Stage 1 RSA 2nd Addendum - Response Report

1.1 This report results from receipt of a Stage 1 RSA Addendum 2 Report, undertaken dated February 2018.

Persimmon Homes Thames Valley
North Littlehampton, Lyminster Bypass (Southern Section)
Stage 1 RSA 2nd Addendum – Response Report

Large Refuse Vehicle (3 axle)	
Overall Length	9.850m
Overall Width	2.450m
Overall Body Height	3.814m
Min Body Ground Clearance	0.356m
Track Width	2.450m
Lock to Lock Time	4.00s
Kerb to Kerb Turning Radius	9.500m

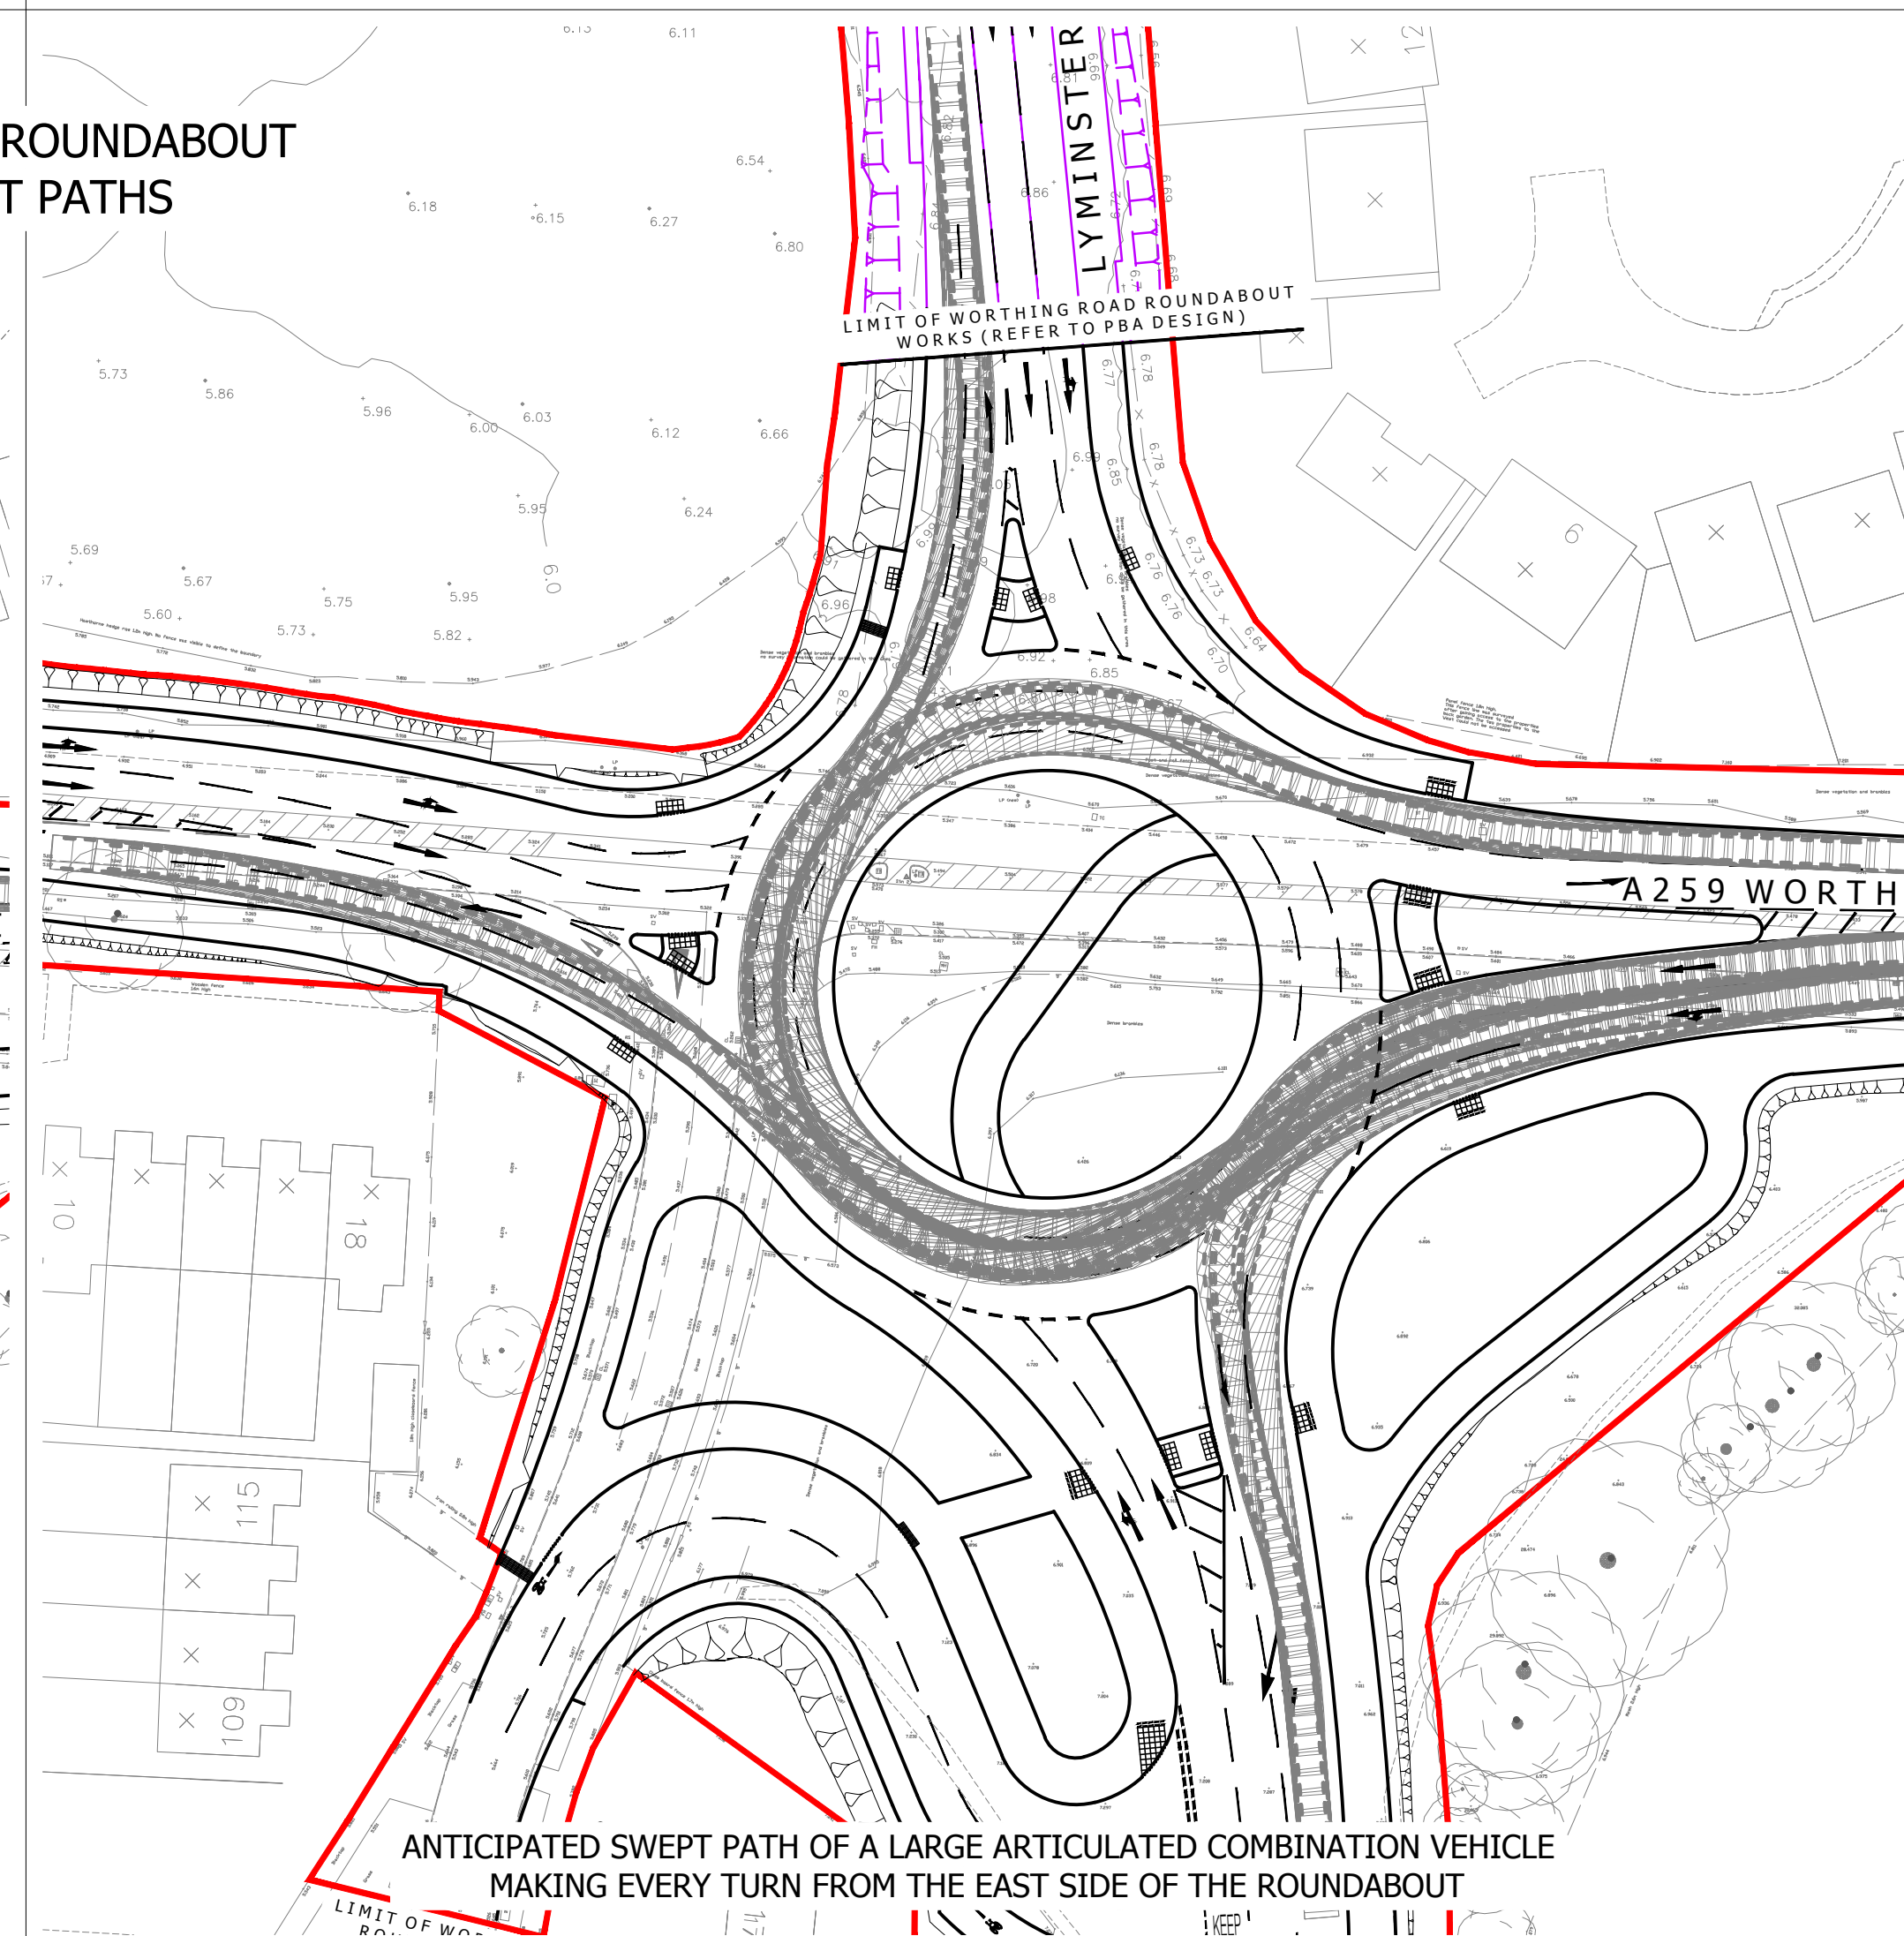
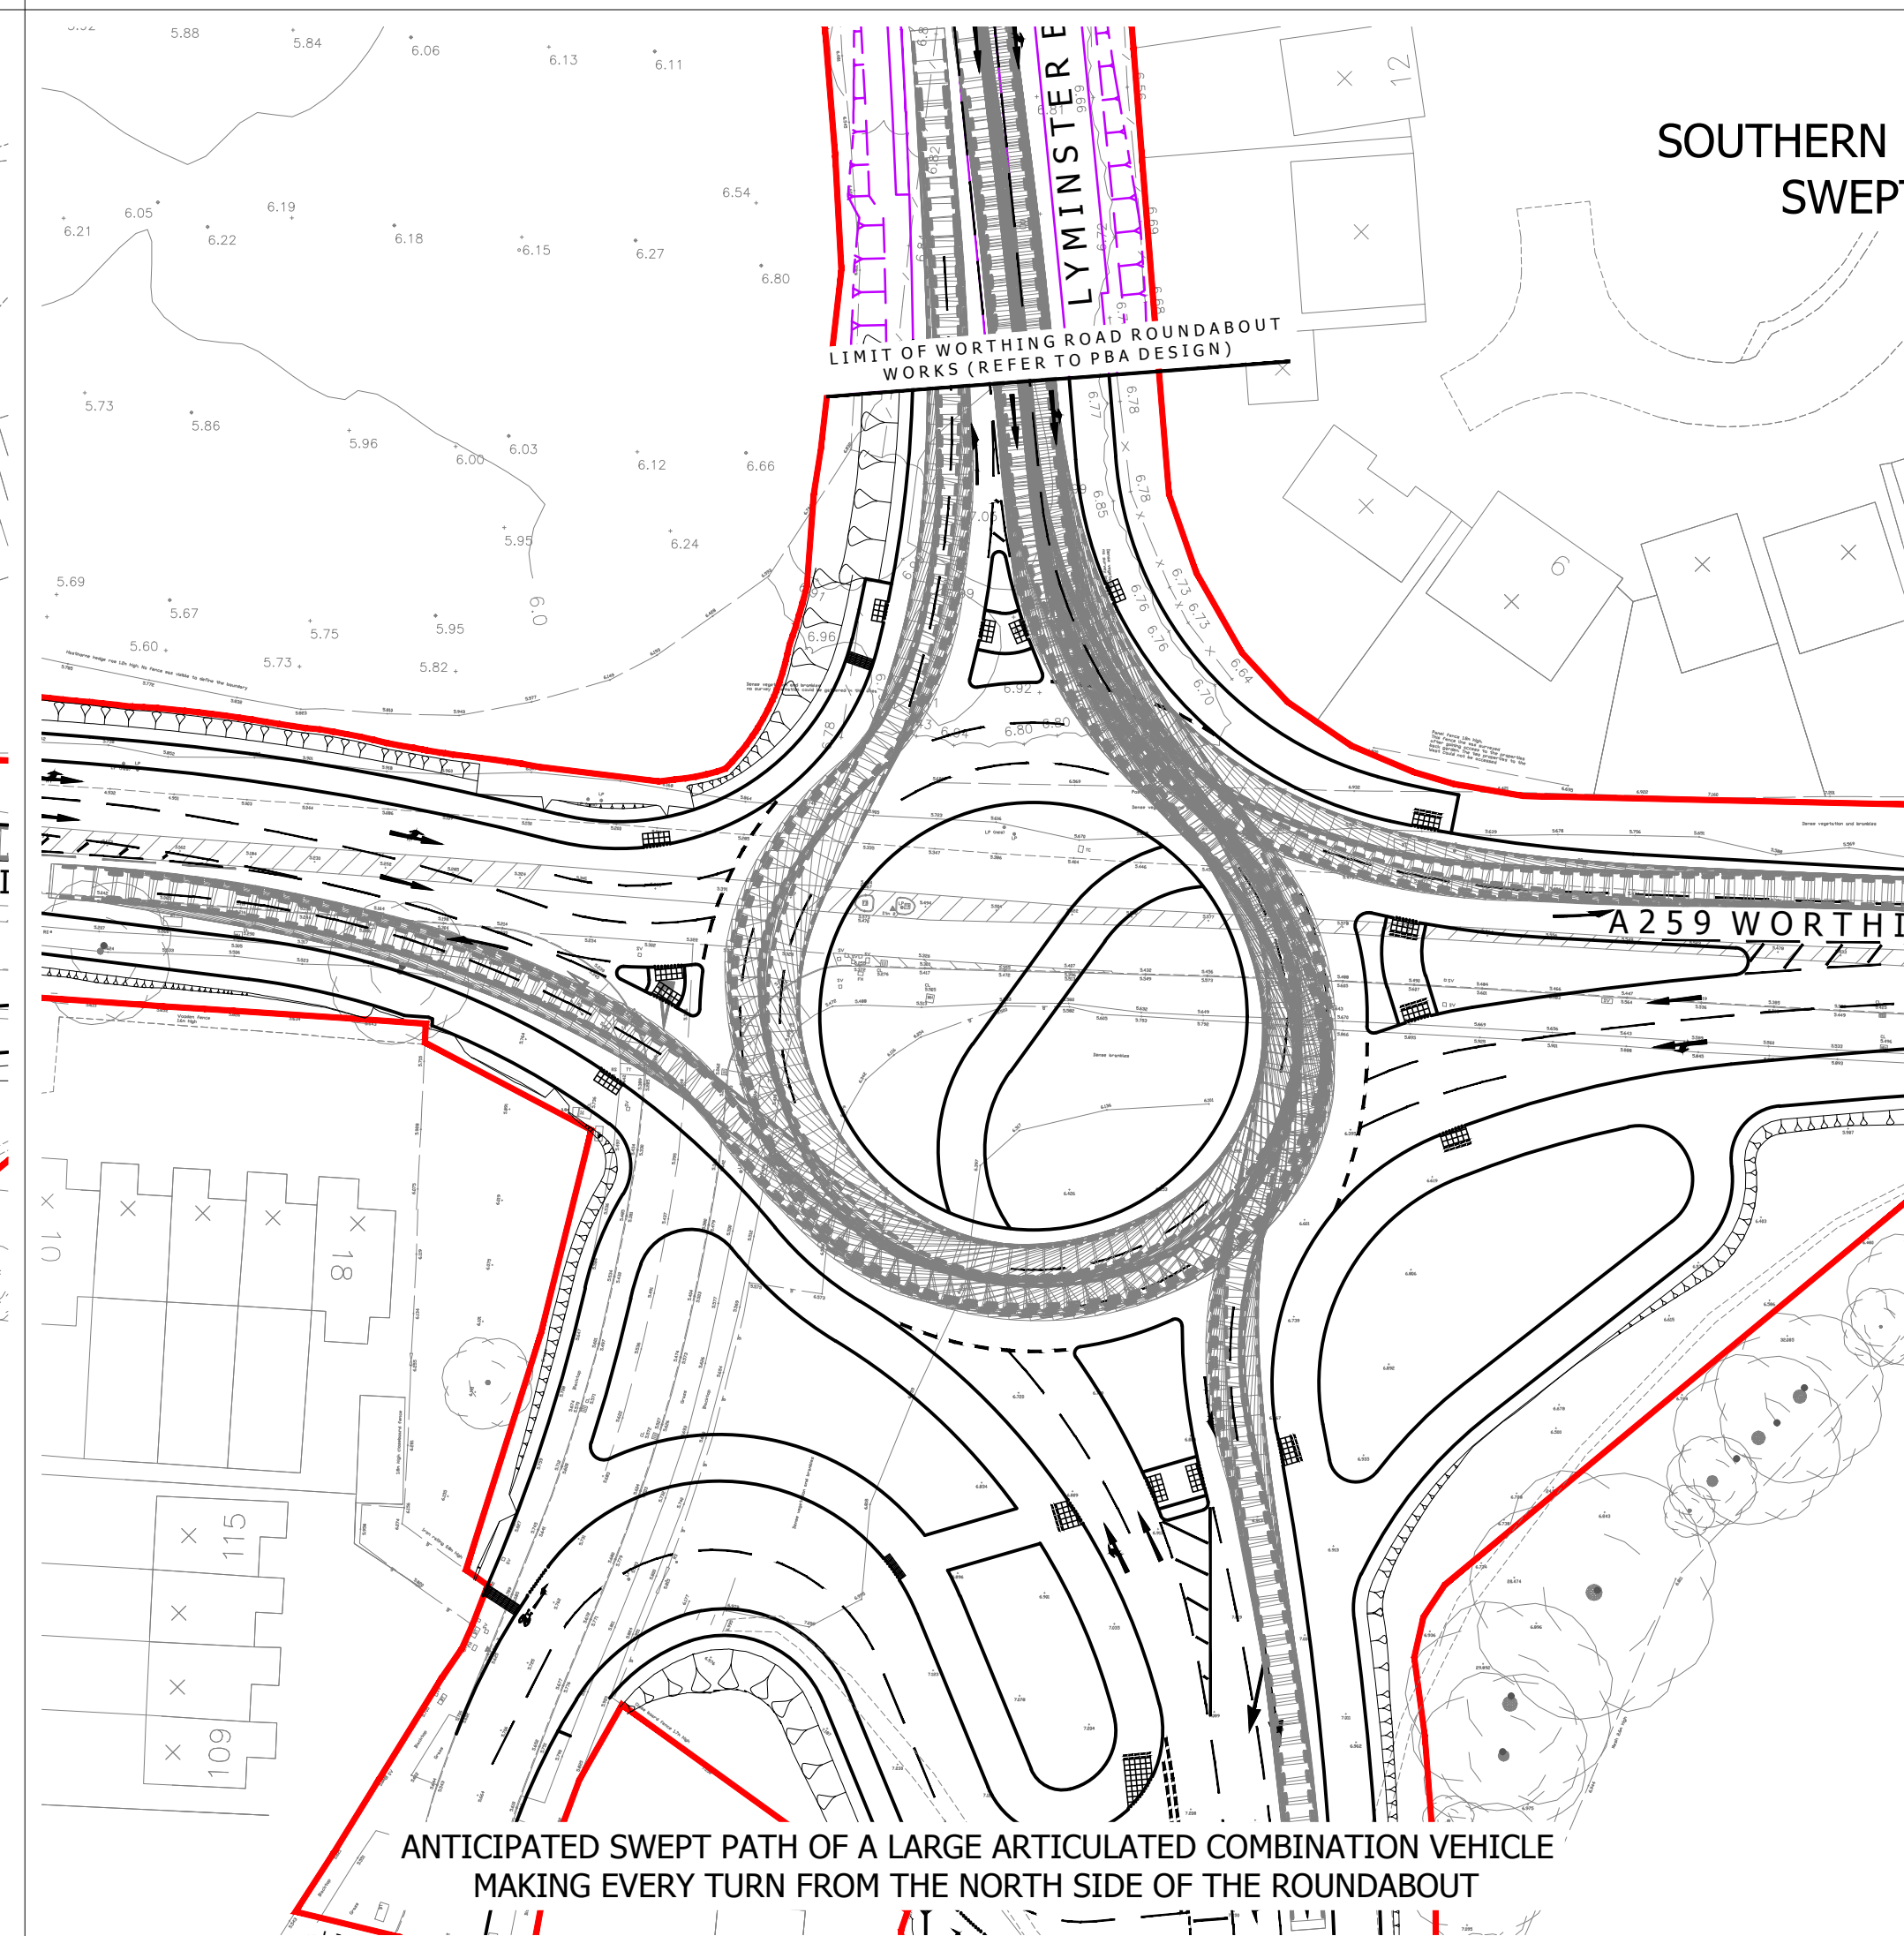
Item	Problem	Recommendation	Designer's Response
3.3	Location: General. Summary: Proposed signage This matter can be dealt with at the detailed design stage. It will be important that the new highway network is clearly signed throughout. - There appears to be insufficient signage provided on the bypass on each approach to the proposed roundabout junctions. - Whilst map-type signs are generally detailed on approaches to the roundabout junctions, there are no map-type signs detailed on the new bypass. - Visibility to proposed road signs (bypass) has not been shown at this stage. - Whilst details of sign types, dimensions and locations have been generally detailed. Sign posts should not be located where they will cause an obstruction/hazard to pedestrians/cyclists. For example, one of the two posts supporting the map-type sign on the eastbound approach to the A259 Worthing Road roundabout junction is located in the centre of the footway.	- Provide signing on each approach to new and modified junctions. - Map-type signs will be required at roundabout junctions. - Ensure adequate forward visibility to signs and ensure adequate clearance between sign face and carriageway. - Where appropriate ensure adequate clearance for pedestrians and cyclists beneath sign face. ~~Provide maximum speed limit signs at all changes of speed restriction.~~ This no longer remains relevant as maximum speed limit signs are provided at all changes of speed restriction	Accepted. - Appropriate signing shall be provided at detailed design stage through agreement with the Highway Authority. - Map type advance direction signs shall be provided on each approach to the junctions as recommended. The initial traffic signing locations indicated on the drawings are provided to show the intention to provide advance and direction signing. - Adequate visibility to traffic signs shall be provided. Adequate clearance between the sign face and carriageway shall be provided as recommended. - A clearance of 2.40m shall be provided beneath sign faces for pedestrians and cyclists. <i>An initial signing strategy has been developed for review by WSCC and includes ADS signs on the Bypass approaches to the roundabouts (MB drawing numbered A/PHLYM.1/TS01 Rev P1). It is intended that this will be discussed further and agreed at detailed design stage.</i>
